SITE PLAN

PART OF THE SOUTHWEST QUARTER, SECTION 29, TOWNSHIP 13 SOUTH,
RANGE 64 WEST OF TH 6TH P.M.,
COUNTY OF EL PASO, STATE OF COLORADO

SITE PLAN

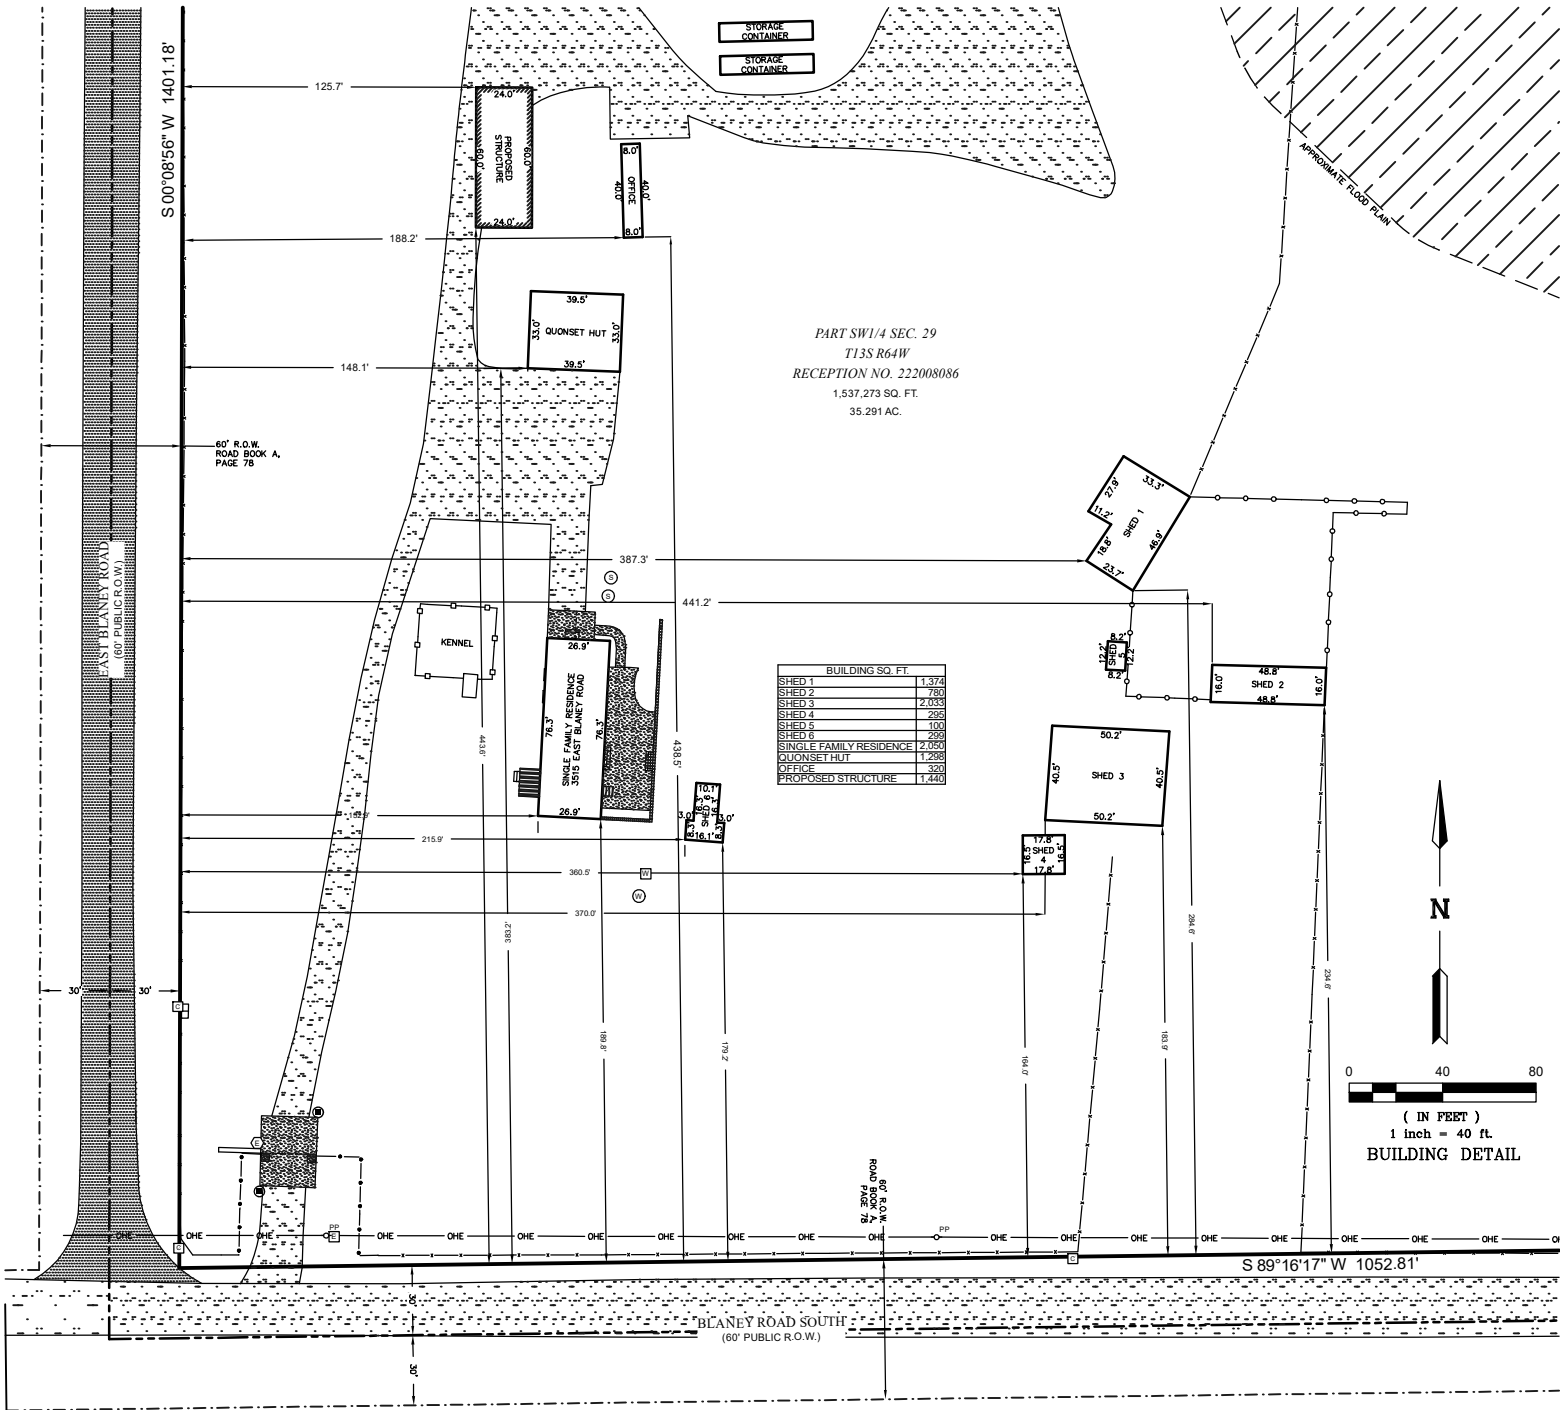
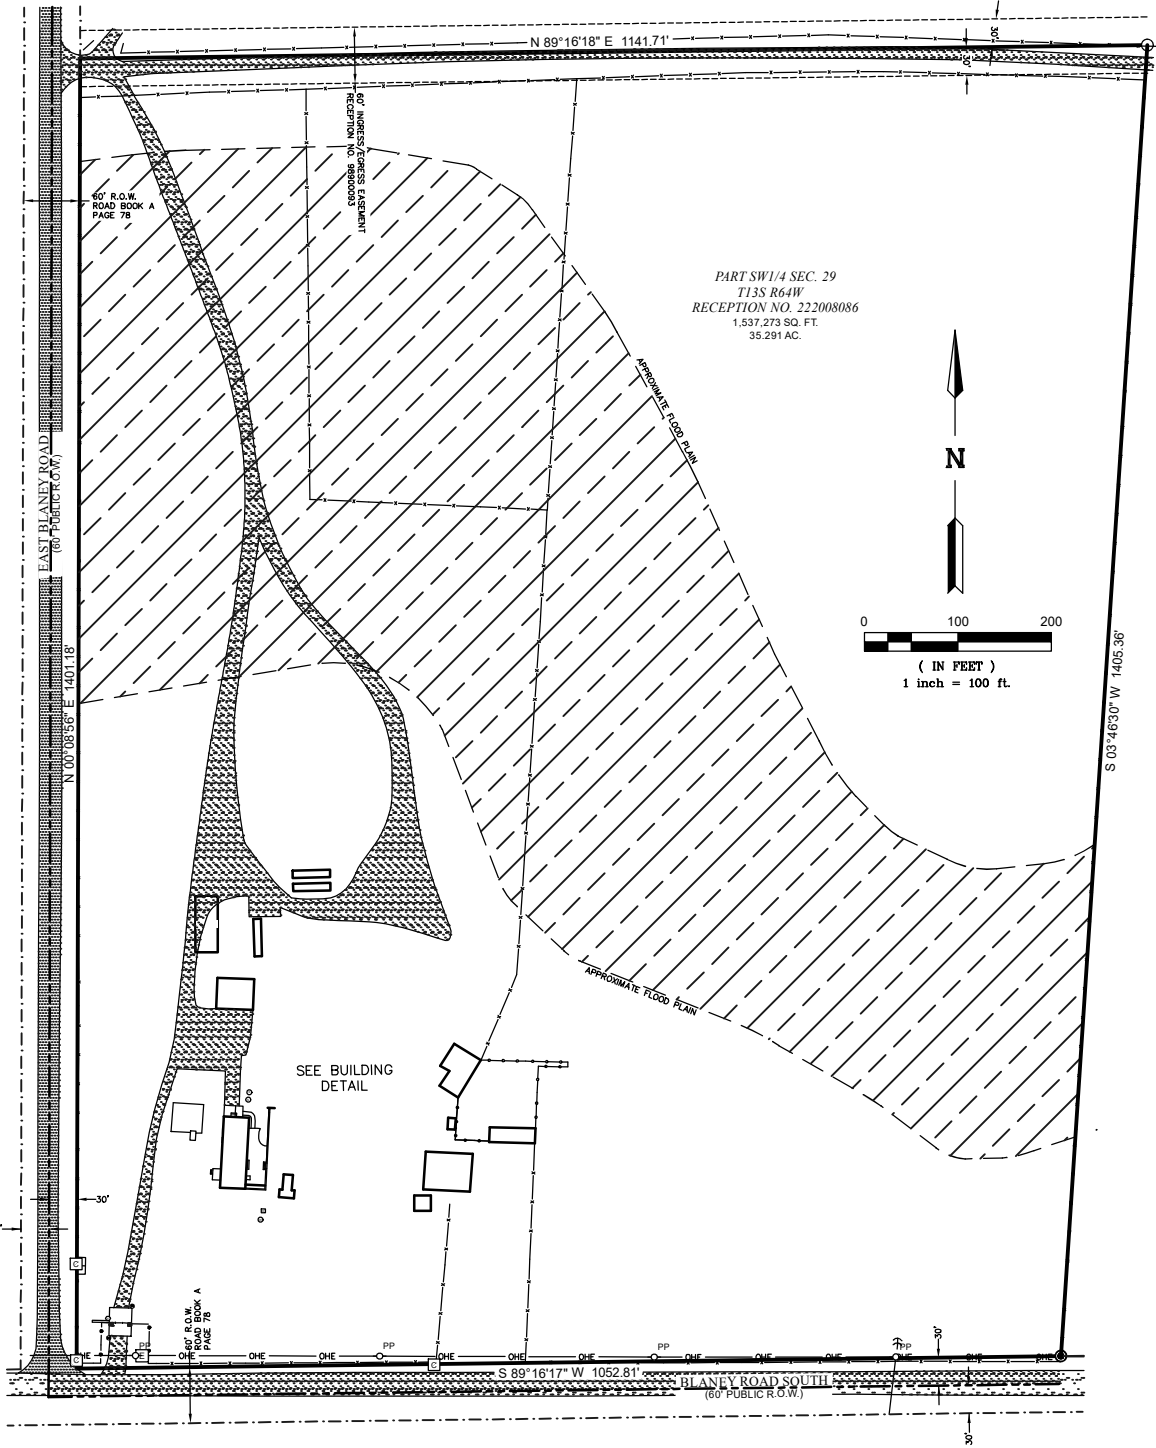
Label traffic ingress/egress.

You previously mentioned that this entrance is for business operations. Label and provide width measurements.

For future site plan changes, please keep in mind that all outside storage of vehicles and/or materials must be at least 50 ft from the property line and must be screened with fencing or landscaping.

At a minimum, the area must be depicted on this site plan. The specific method of screening can be addressed during the Site Development Plan if you choose to postpone providing that detail.

All outside storage, parking, and work areas are limited in combination to a 1-acre area. This needs to be clearly depicted.

Please depict areas of material, work vehicle, and employee vehicle storage. Refer to note on RIF Acknowledgement regarding a suggestion to consolidate outdoor footprint. If consolidating outdoor footprint from what is existing, please discuss in the letter of intent.

If this entrance is residential only, please label as such.

Unresolved Review 1 Comment:
Please depict the FEMA Floodplain from the Draft CWCB study on this site map. Please note that any future disturbance within the floodplain will require a floodplain development application (<https://www.pprbd.org/File/Resources/Downloads/Floodplain/FLPLApplication.pdf>) and a no-rise certification completed by a professional engineer.

This is a great site plan for current site conditions, but we need to address the proposed conditions. Details about the Home Occupation need to be called out and identified. Please add a focus area specifically for business use (similar to the "building detail" below).

ADD: "To be removed." per the Letter of Intent.

Add "proposed" to everything that is not permitted but will be established and permitted through this process.

Please identify if these are residential accessory structures **OR** if they are accessory structures to be used as part of the Home Occupation.

Please identify what structures will be used for the Special Use

Existing access width on the south of the property does not appear to be drawn to scale (it's shown as smaller than actual).

Please revise to be 60' Public Local ROW.

ADD: Note that acknowledges the following comment from MVEA - (within EDARP, dated 2/5/2026)

MVEA has existing electric and/or broadband facilities near and within this parcel of land. If there is any damage, removal or relocation of facilities it will be at the expense of the applicant.

ADD: "PCD File No. AL265"
